From:
To: [DCAdmin](#)
Subject: Planning Application Reference 2020/90996
Date: 27 April 2020 21:53:53

Please find below comments in opposition to the planning application referenced above. I am a resident of Moorhouse Drive

UPRN	Originator	Zone	Level	Type	Role	Series/Number	Revision:
BIERM-NJA-02-XX-DR-A-PL_15							
Date:	Drawn:	Checked:	Scale:	@A3	Int Job No:		
03/23/20	NjH	nj	1 : 100		19/157

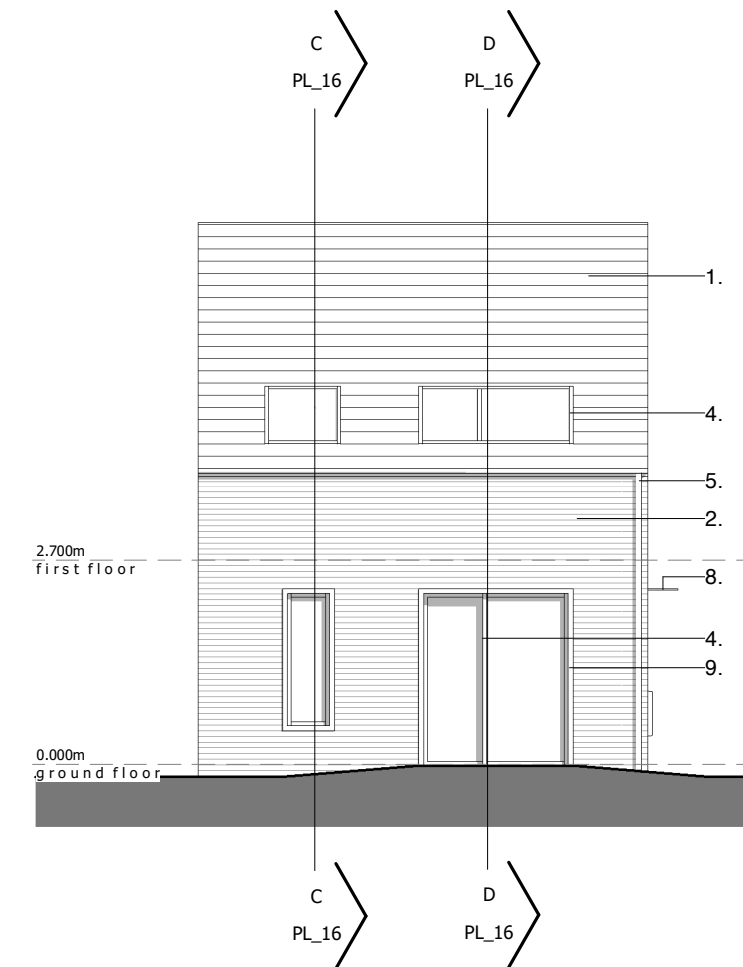
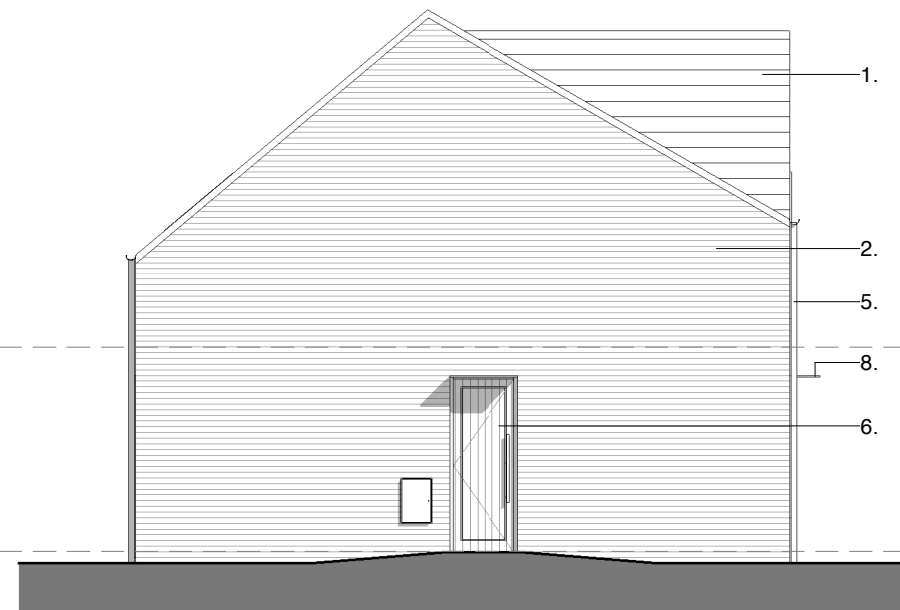
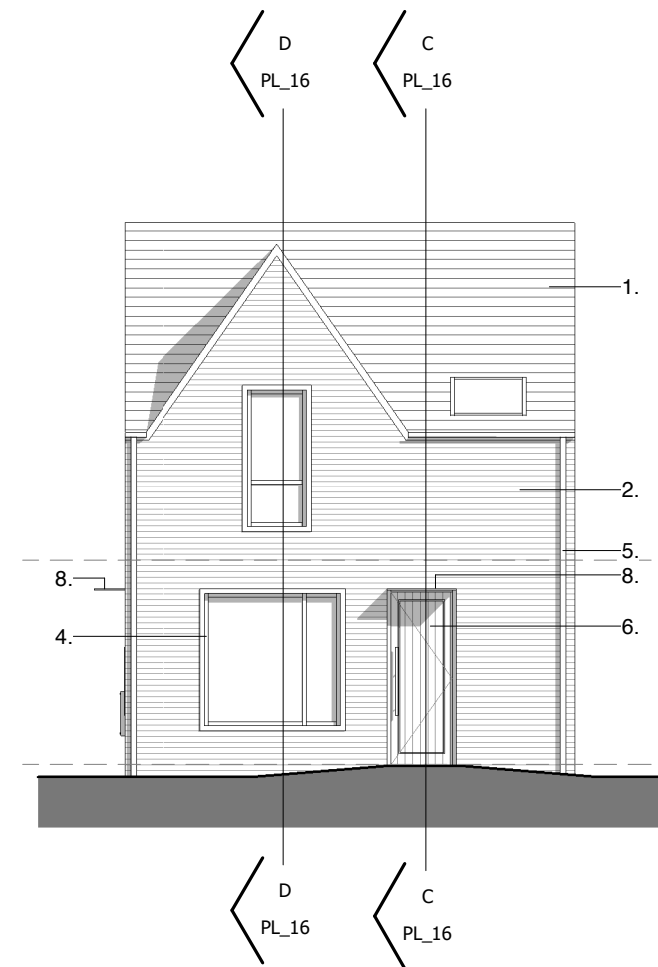
2. The design of the terrace with rooms in the eaves and floor to ceiling dormer window coupled with the land being higher than Moorhouse drive results in them overlooking the property labelled #11

4. Proximity of one of the terrace buildings to the boundary fence of number 11
5. The land proposed for development is higher than that of 11 and 15 Moorhouse drive. During heavy rain there has been run off of surface water into these rear gardens and this will be exacerbated by tarmacing the open land behind.
